Reference No:	2025/65/92460/W
Site Address:	Oldfield House, Oldfield Road, Oldfield, Honley, Holmfirth, HD9 6RL
Description:	Listed Building Consent for installation of new windows and doors, internal alterations and erection of boundary wall and gates (within a Conservation Area)
Recommending Officer:	Joshua Merriman

DECISION – GRANT LISTED BUILDING CONSENT

Case Officer Report – 2025/92341

Drg. no.	Rev.
307-25-PL04	D

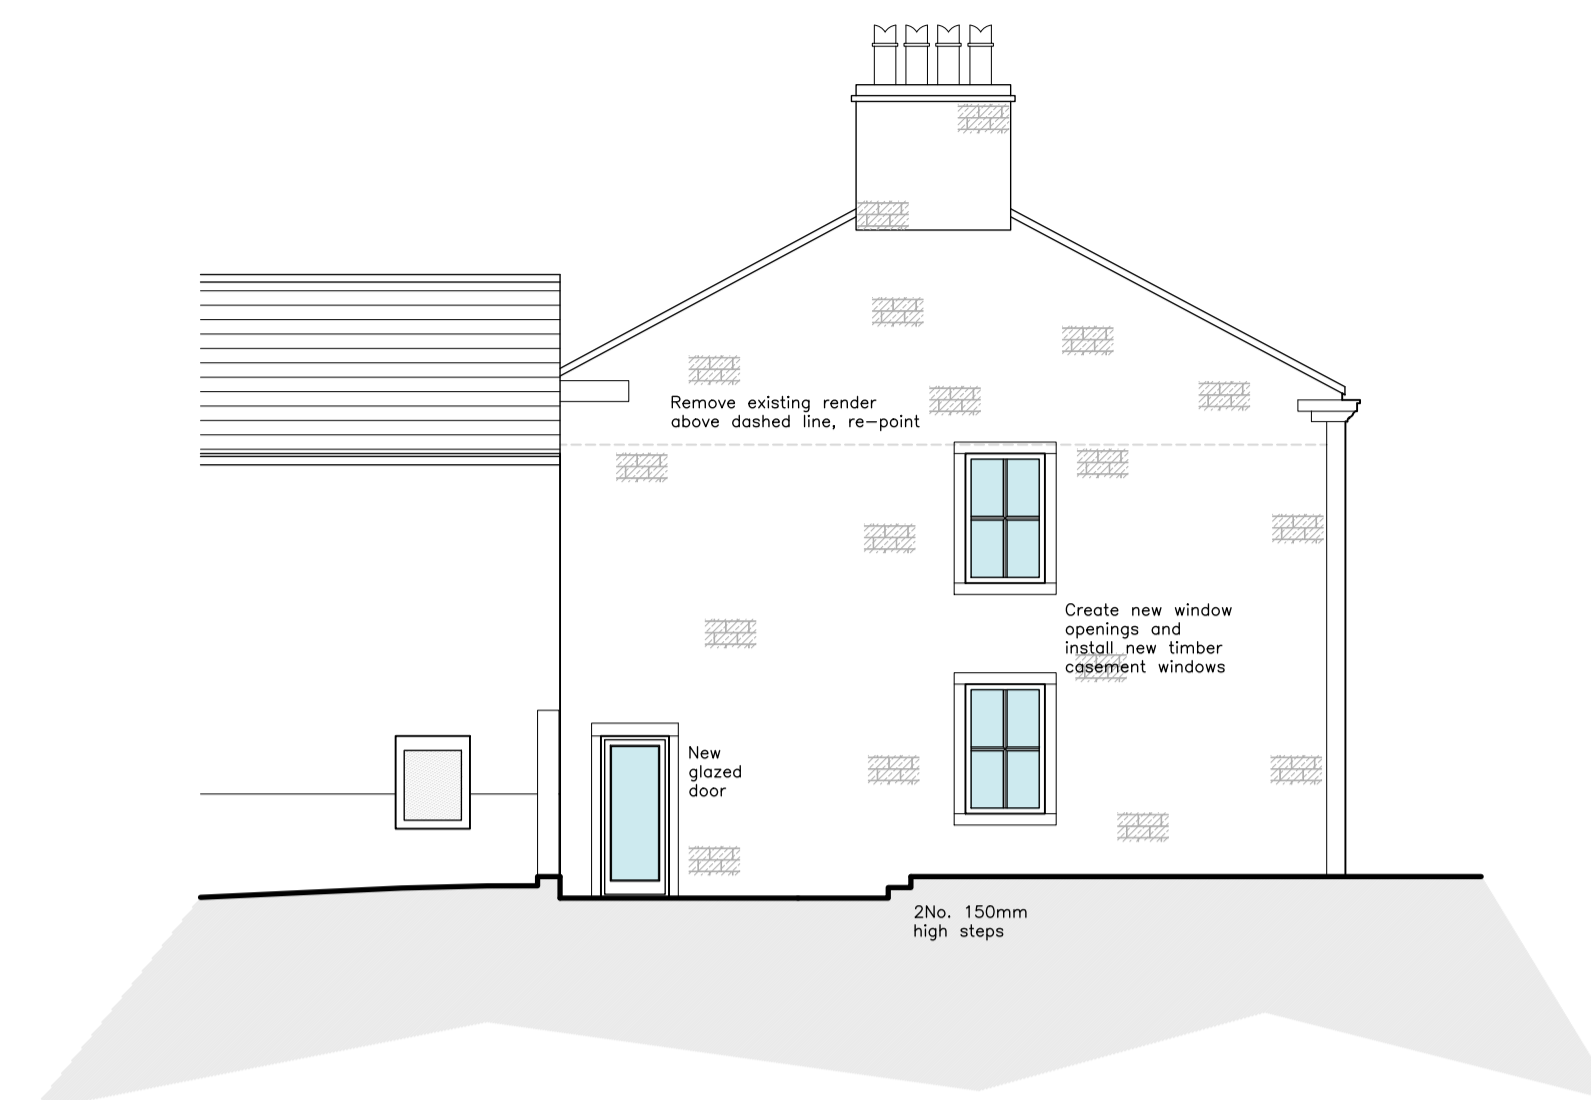
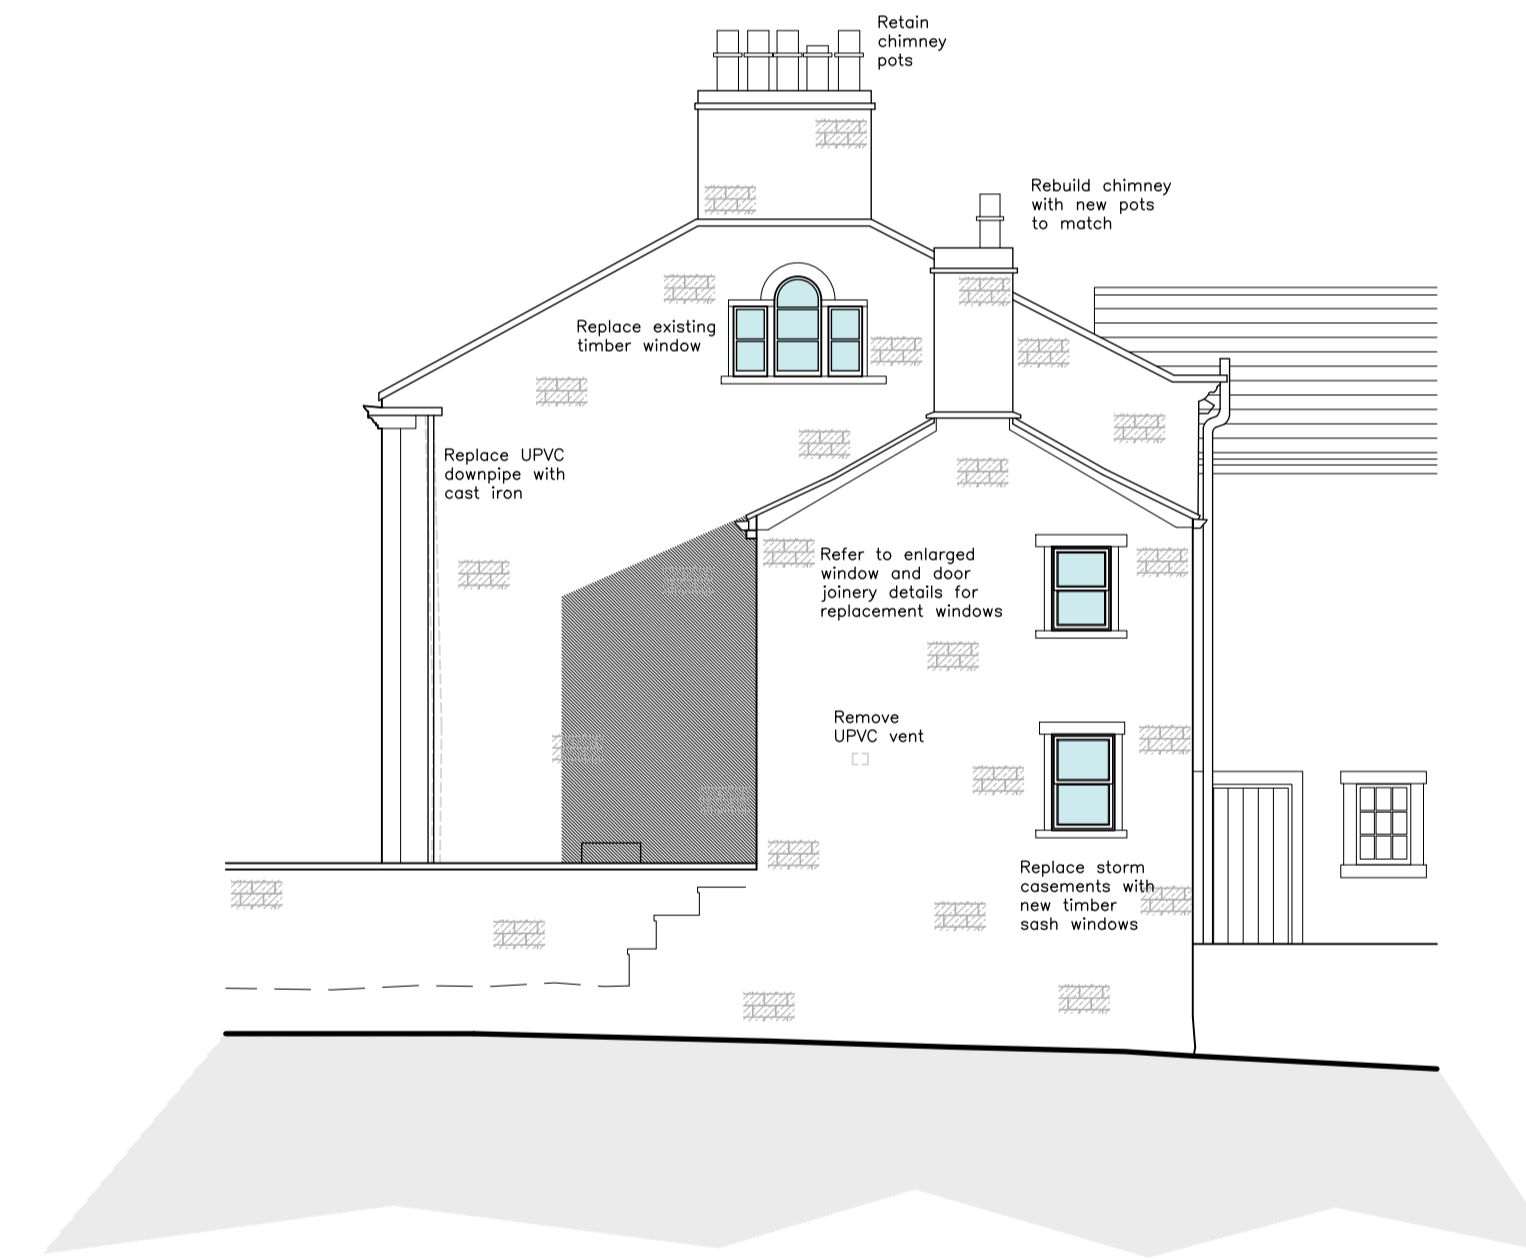
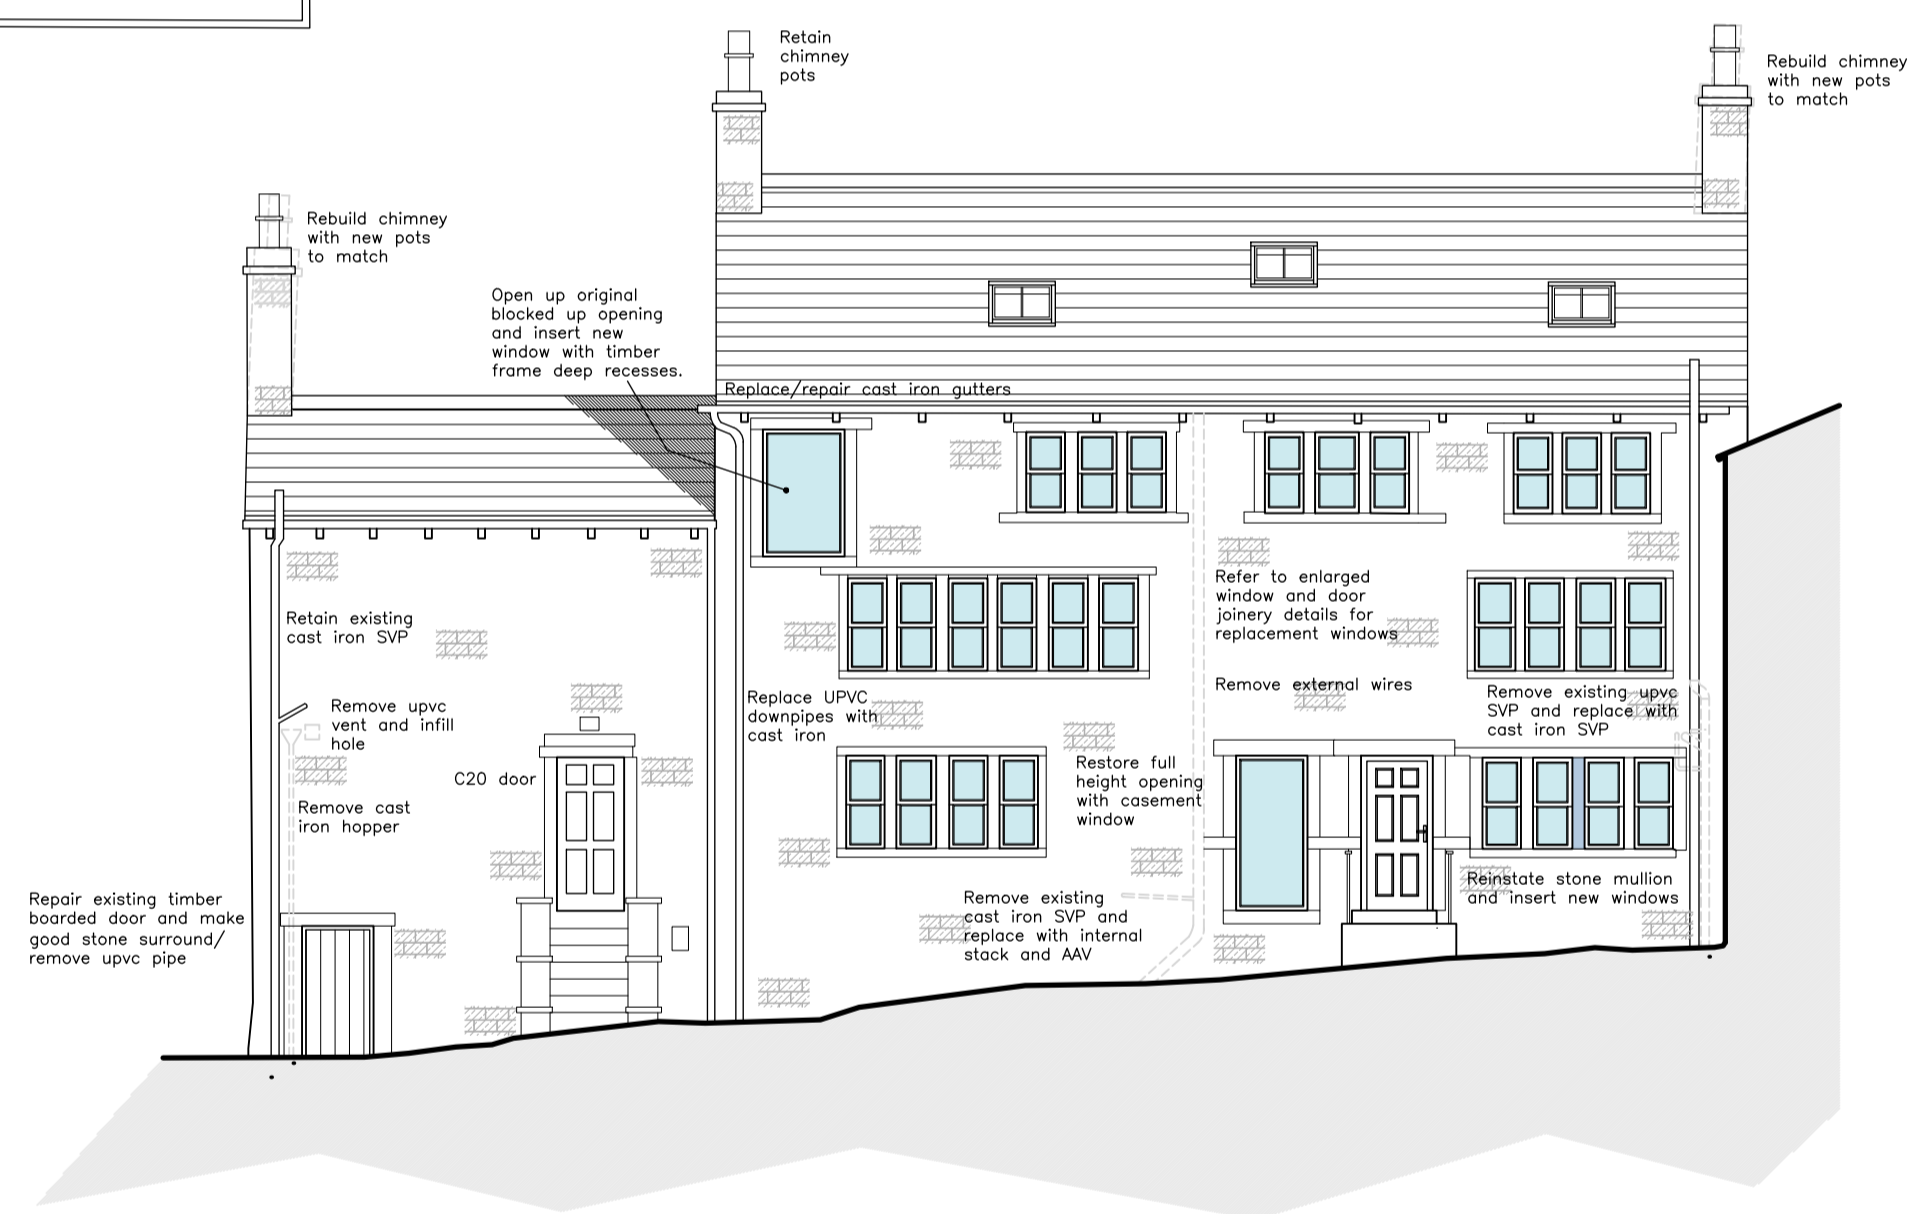
Following a consultation with KC Conservation & Design, it was requested that additional information regarding the date of the staircase proposed to be demolished was submitted and amended plans detailing the removal of one proposed rooflight, and alignment of the remaining rooflights were also submitted. The applicant submitted these details and amendments to the case officer, and they were considered as acceptable.

8. Notwithstanding the approved plans, the proposed roof lights shall be of a conservation style and sit entirely flush with the roof plane.
